PLANNING APPLICATION CONSULTATION RESPONSE

Application Number:	3/2025/0100
Proposal:	Proposed hotel development comprising two-storey building (use class C1) with associated parking and landscaping, bin store, air conditioning units and new pedestrian access.
Location:	Land at The Eagle at Barrow Clitheroe Road Whalley BB7 9AQ

Objection 1 – Inadequate Surface Water Sustainable Drainage Strategy

PJA Ref 08336	Scale @ A1 1:200	Date 07/01/2025
Drawing No. 08336-WR-0500		Revision P2
Primary Contact kerry.whitehouse@pja.co.uk

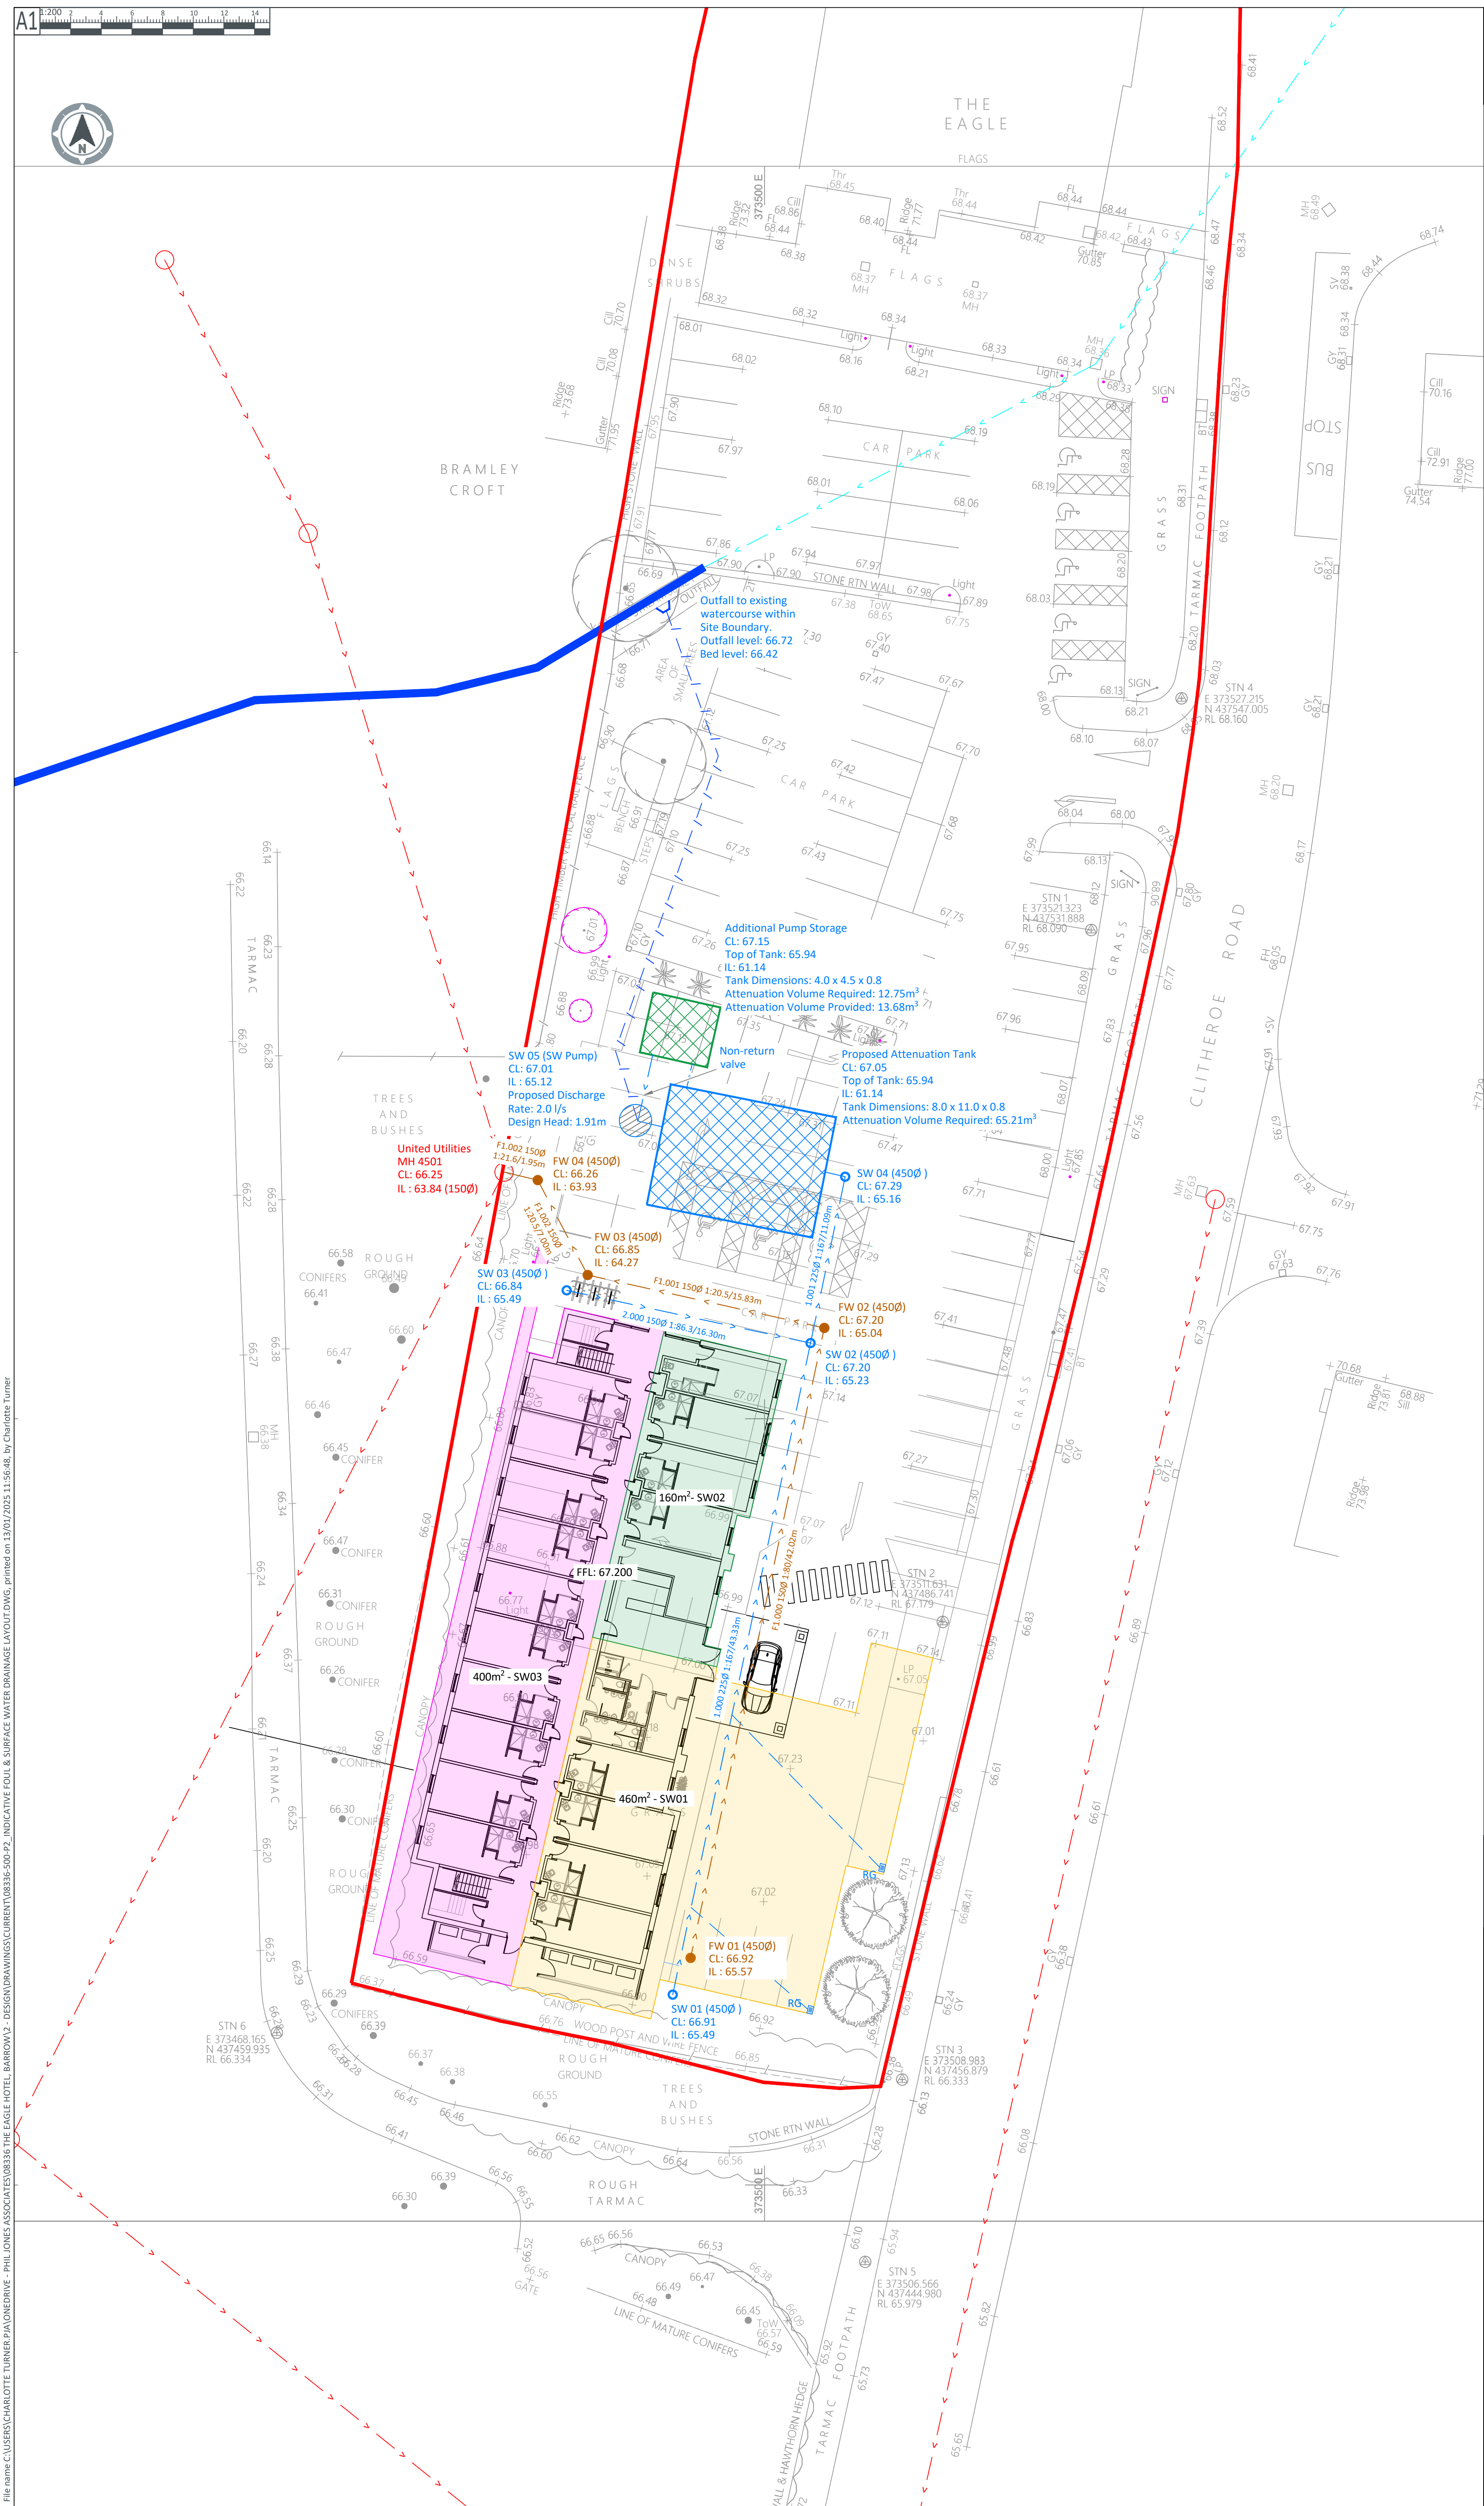
In particular, the submitted surface water sustainable drainage strategy fails to:

1. **Provide evidence to demonstrate why pumping is required** to drain the development site in line with Standard S12 of the Defra Technical Standards for Sustainable Drainage Systems.

Standard S12 of the Defra Technical Standards for Sustainable Drainage Systems requires that pumping should only be used to facilitate drainage for those parts of the site where it is not reasonably practicable to drain water by gravity. The applicant has not provided robust evidence as to why pumping is required to drain the development site, nor provided evidence as to why the proposed drainage system cannot be drained by gravity. This is sufficient reason in itself for a refusal of planning permission.

You can overcome our objection by submitting information that covers the deficiencies highlighted above and demonstrates how surface water will be managed on-site, to satisfy Paragraphs 181 and 182 of the National Planning Policy Framework, the Planning Practice Guidance, and the Defra Technical Standards for Sustainable Drainage Systems. If this cannot be achieved we are likely to maintain our objection to the application. Production of this information will not in itself result in the removal of an objection.
